**Consultation Response from KC,
Highways Development Management**

2026/91869 4, Armytage Crescent, Lockwood, Huddersfield, HD1 3TY

Change of use of residential dwelling (Use Class C3) to childrens care home for up to two children (Use Class C2) with external alterations

Date Responded: 10 August 2026

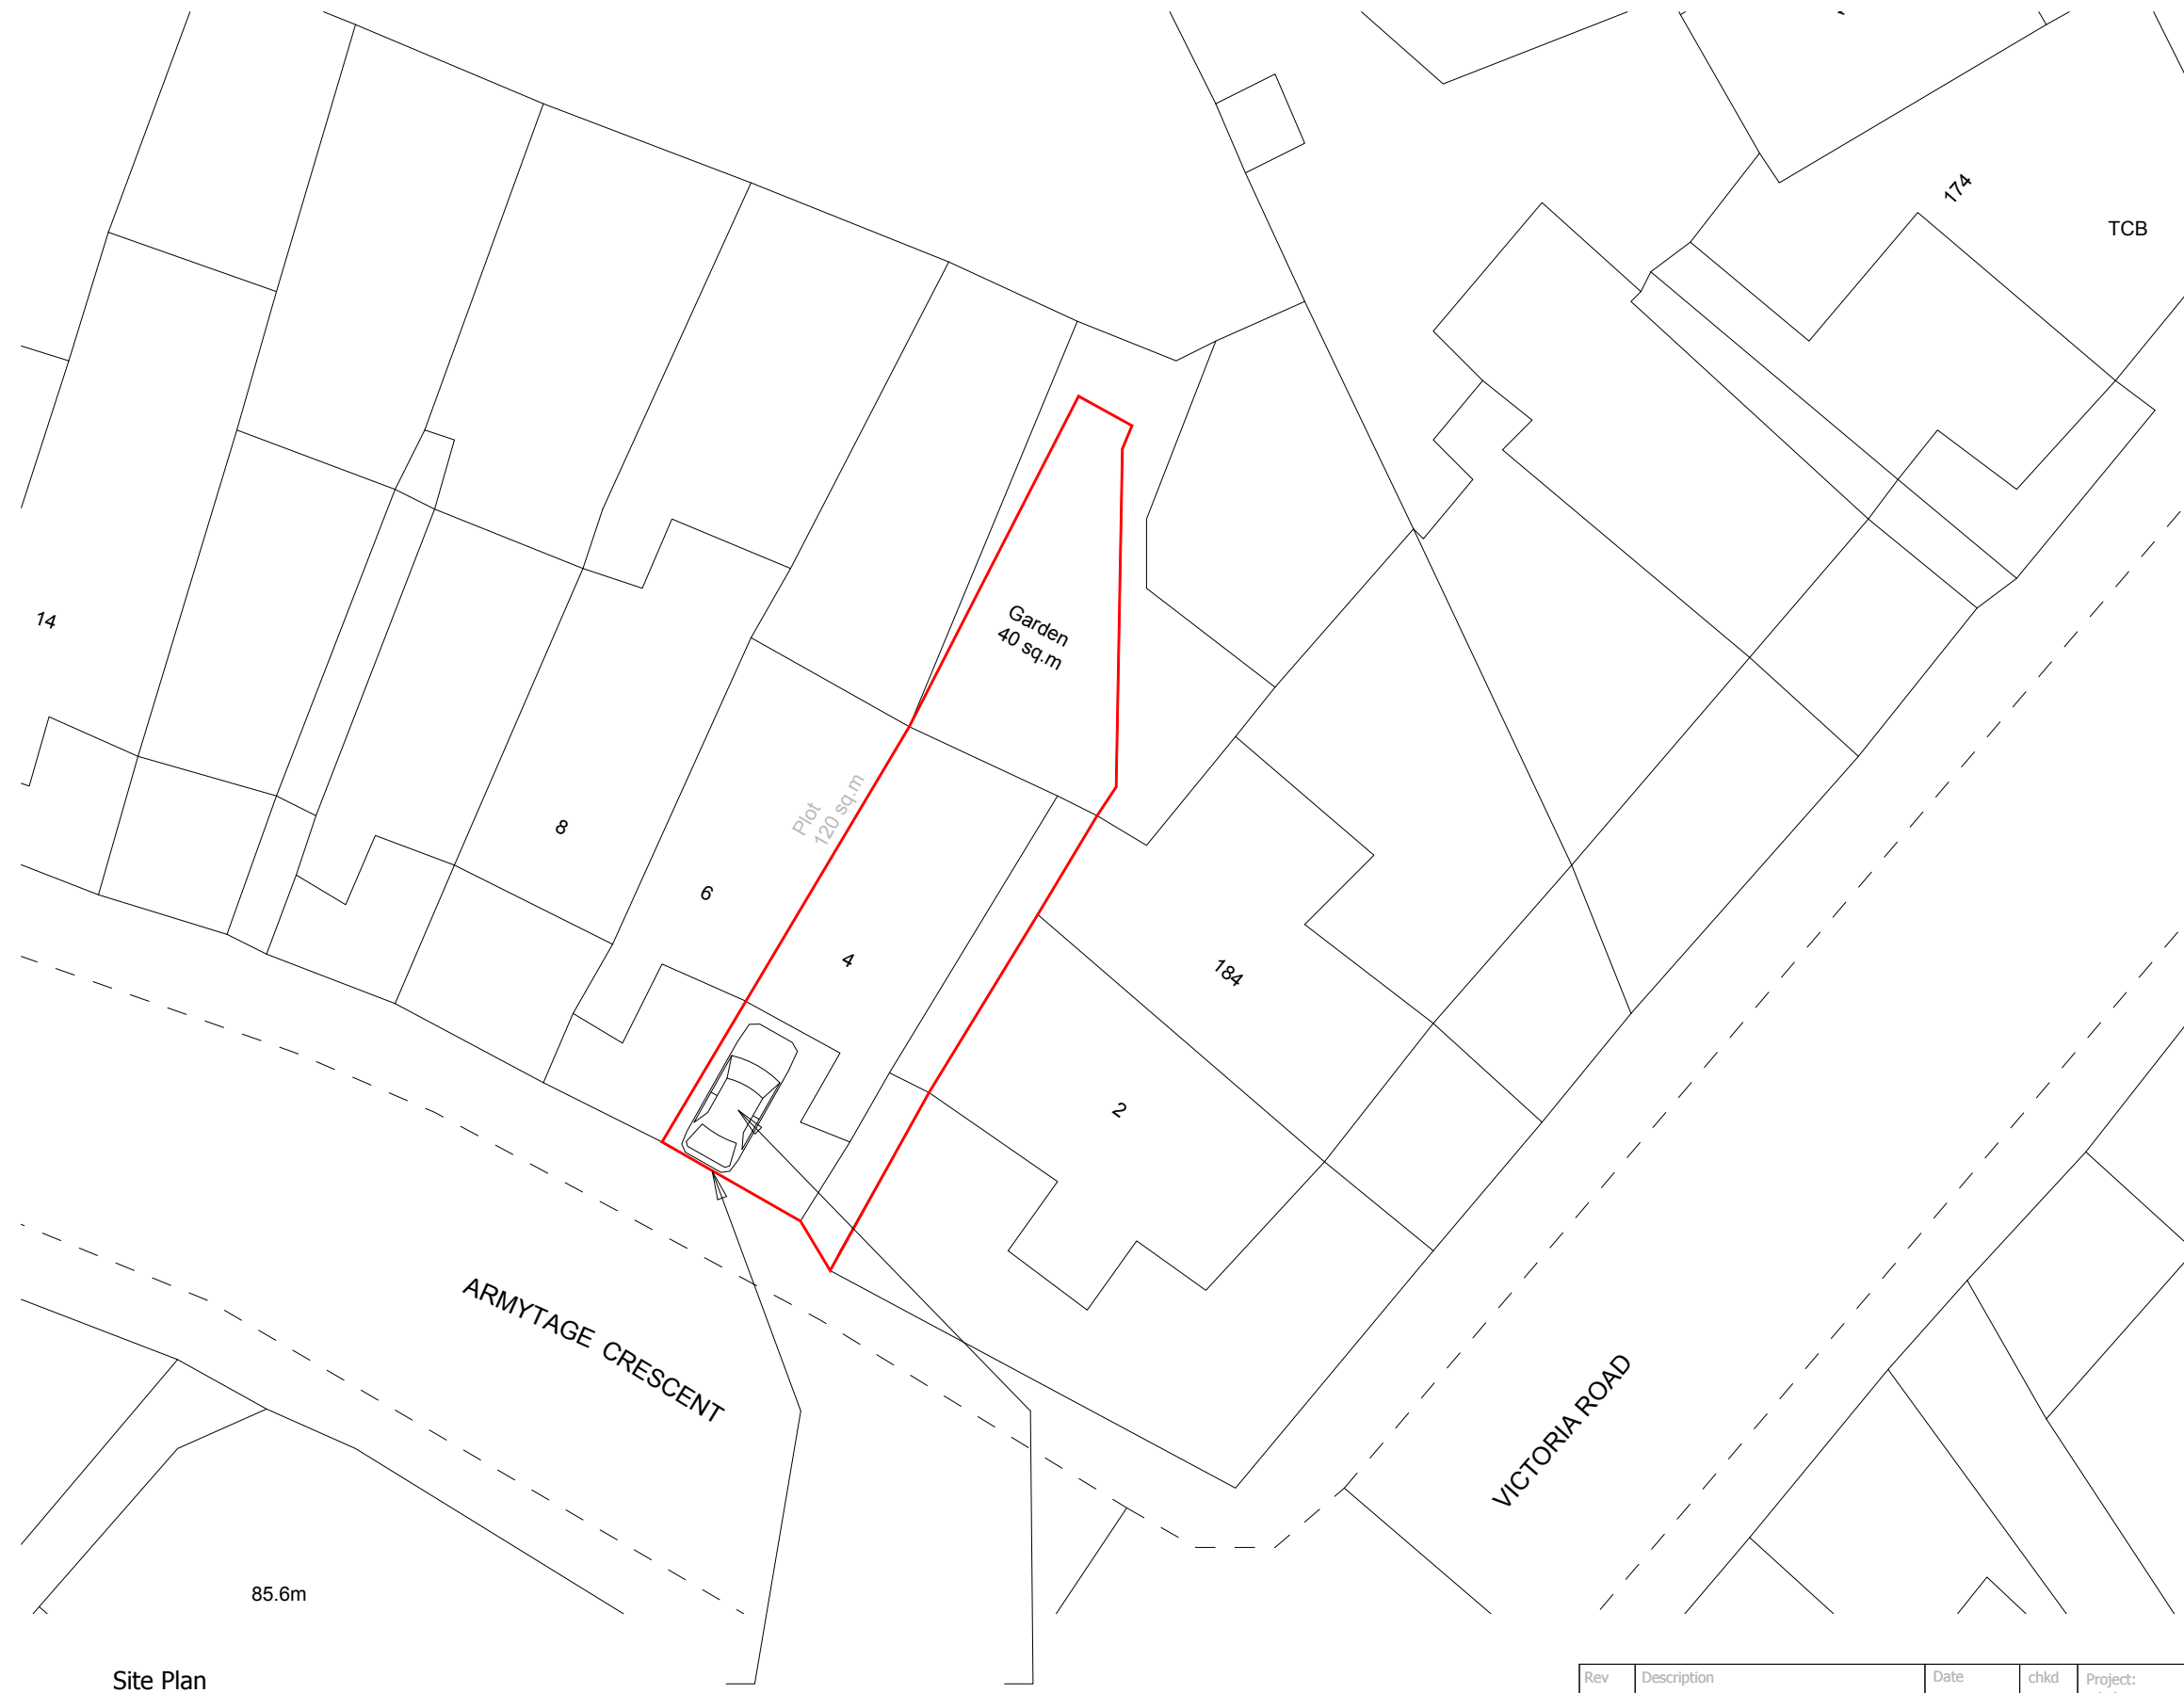
Objection: Inadequate space for car parking.

Plan ref: PL02.

The proposed for change of use from a four bedroomed dwelling to three / four bedroomed residential children's care facility would be served from Armytage Crescent with the creation of a new vehicular access to provide one driveway parking space.

A cycle store is necessary to support policy LP20, Active Travel objectives and mode choice. This should be suitable for one bicycle to meet the desired requirements in the KHDG SPD, although preference is for a minimum of two spaces to provide an option for residents and staff. Electric bicycles should be considered too.

A new vehicular access is proposed from Armytage Crescent to serve a driveway parking space, but there is insufficient depth to meet the minimum requirements of 5 x 2.5m for driveway parking criteria to secure a dropped crossing since a vehicle is likely to overhang into the footway. There is need for clearance from the cellar. Greater widths are necessary to against walls and boundary features to allow for access to car doors and opening. Cars have increased in size too and more typical widths for driveway space are now 5 x 3.2m or 3.3m.

Due to the inadequacy of the driveway parking an objection is raised for a refusal:

The proposal does not incorporate adequate on-site vehicular parking facilities to the dimensions required by the LPA to the detriment of pedestrian safety contrary to Kirklees Local Plan, policy LP21.

A more favourable approach may be given on omitting the on-site parking and providing cycle storage since no vehicle parking is available on-site now and the existing dwelling is reliant on on-street space on a first come first served basis. Whilst on-site parking would be preferable in highway terms there would be no increase in demand for car parking from the proposed change of use to meet policies LP21 and LP22. This arrangement without driveway parking would be neutral to not cause a significant issue for highway safety and network functionality.
